COMMUNITY SERVICES DEPARTMENT

**Subject: Falcon Fire #3
(U-201 Approval of Location)**

The Community Services Department has reviewed the development application for Falcon Fire #3 and has the following preliminary comments on behalf of El Paso County Parks. This application will be presented to the Park Advisory Board on June 10th and its recommendation will be provided after the meeting.

NEW STATION SITE PLAN  
FALCON, COLORADO

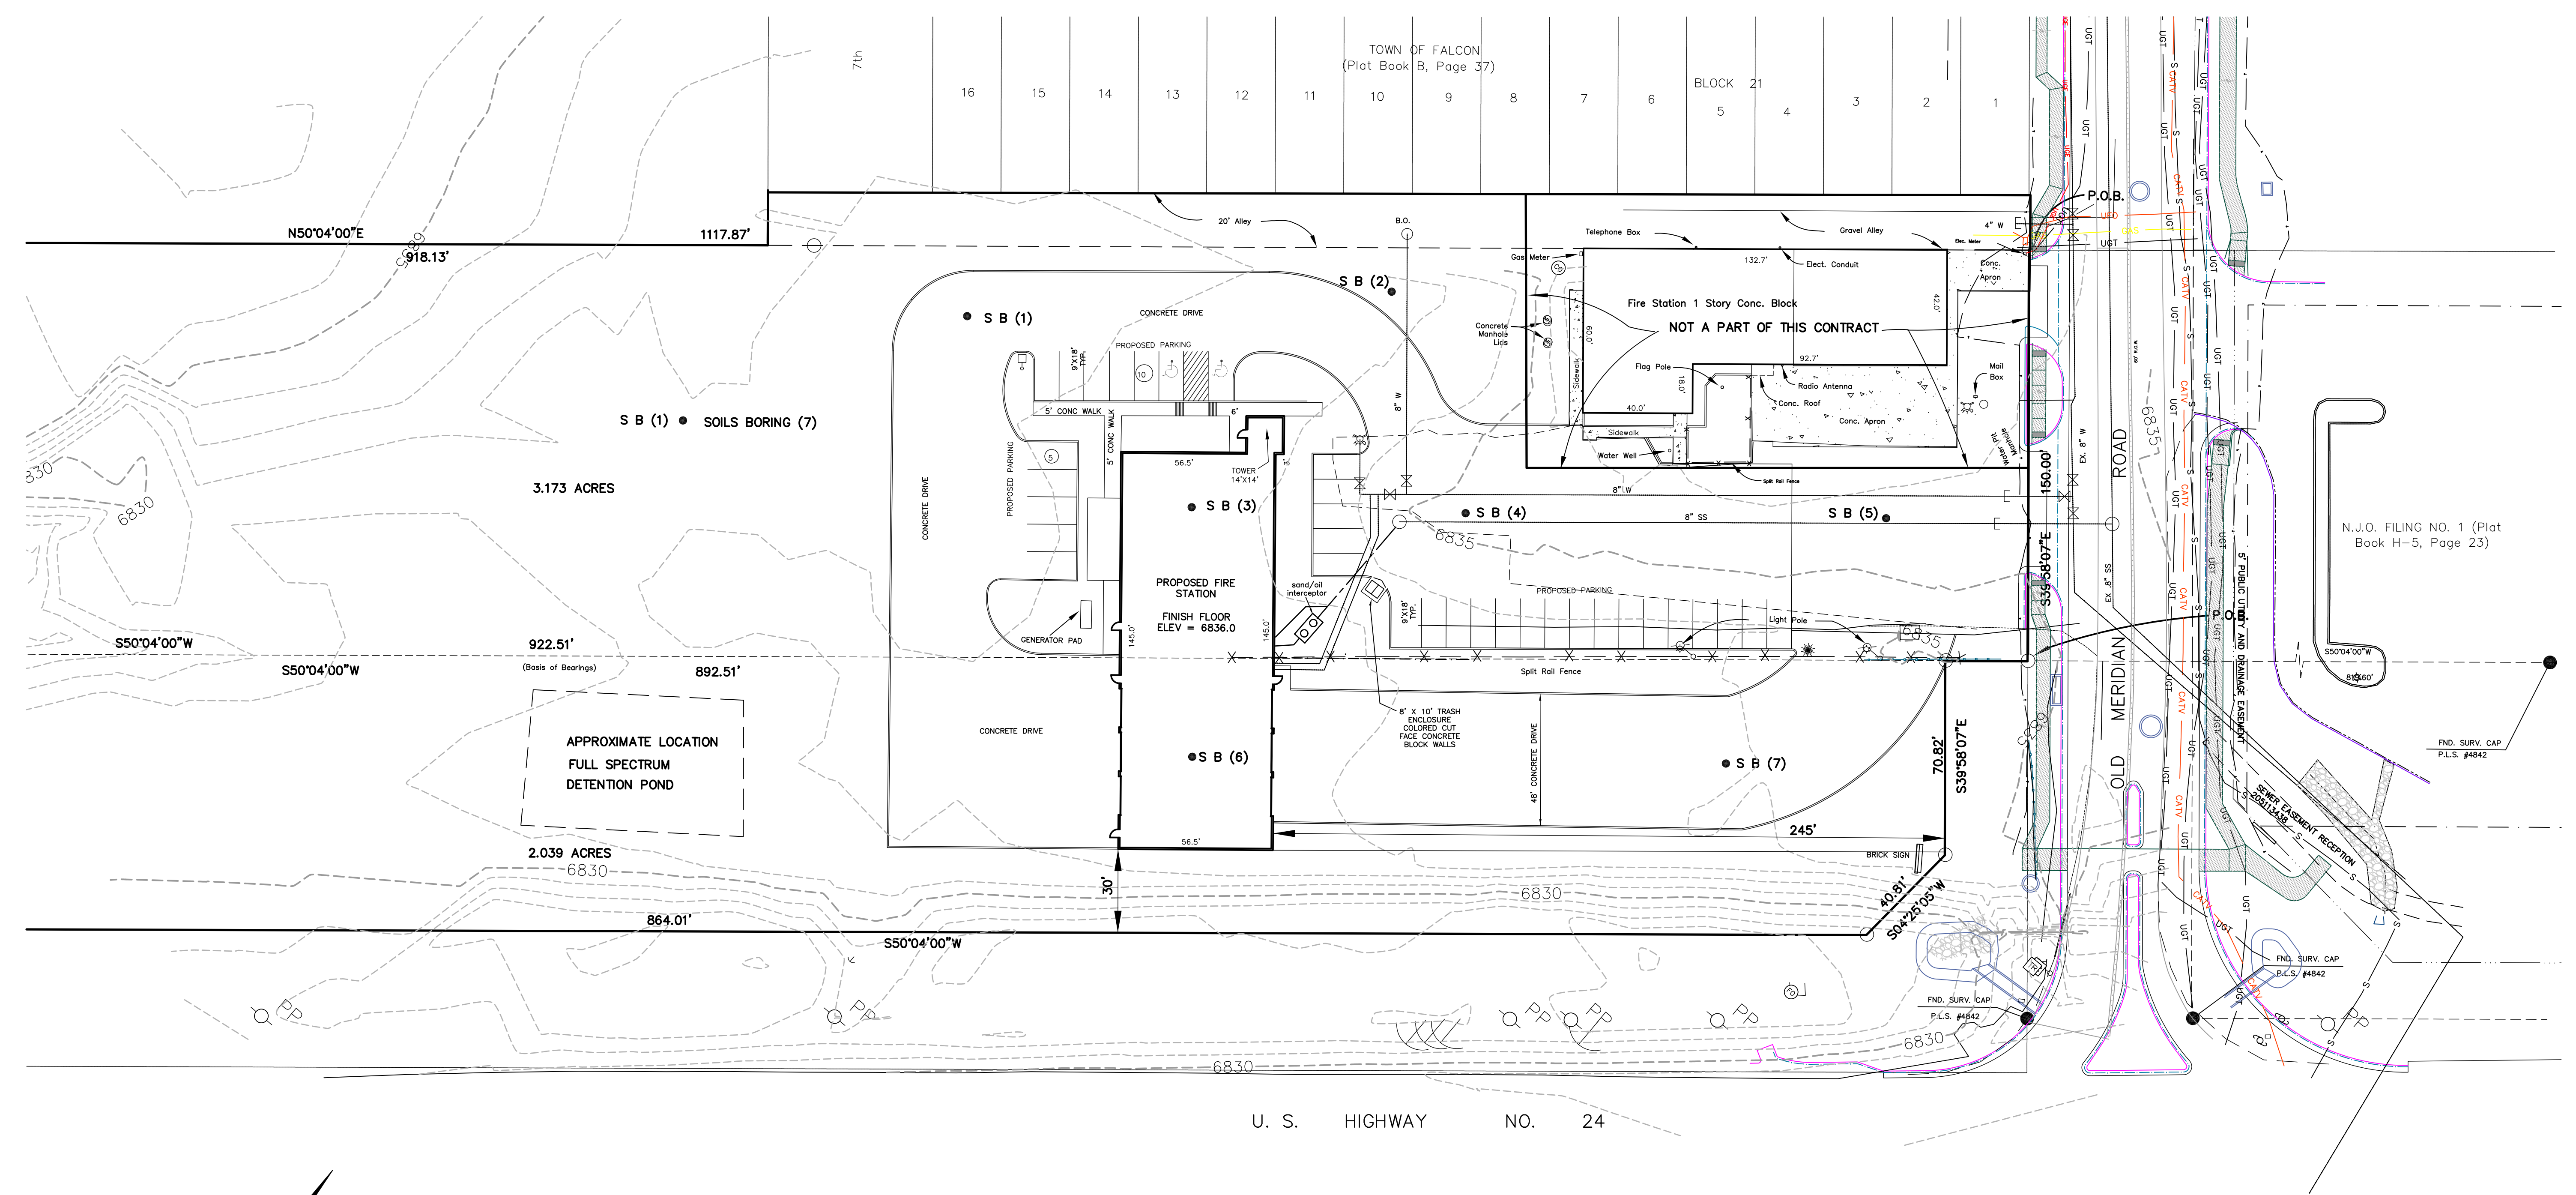
County Parks requests trail easements where development projects impact proposed County trails. As it pertains to this application, the County requests that the applicant provide a 25-foot public trail easement along the south side of parcel #5312400014 that allows for the construction and maintenance by El Paso County of a primary regional trail, and this easement shall be shown and dedicated to El Paso County on the Final Plat, Approval of Location, Subdivision Exemption Plat, and forthcoming Site Development Plan.
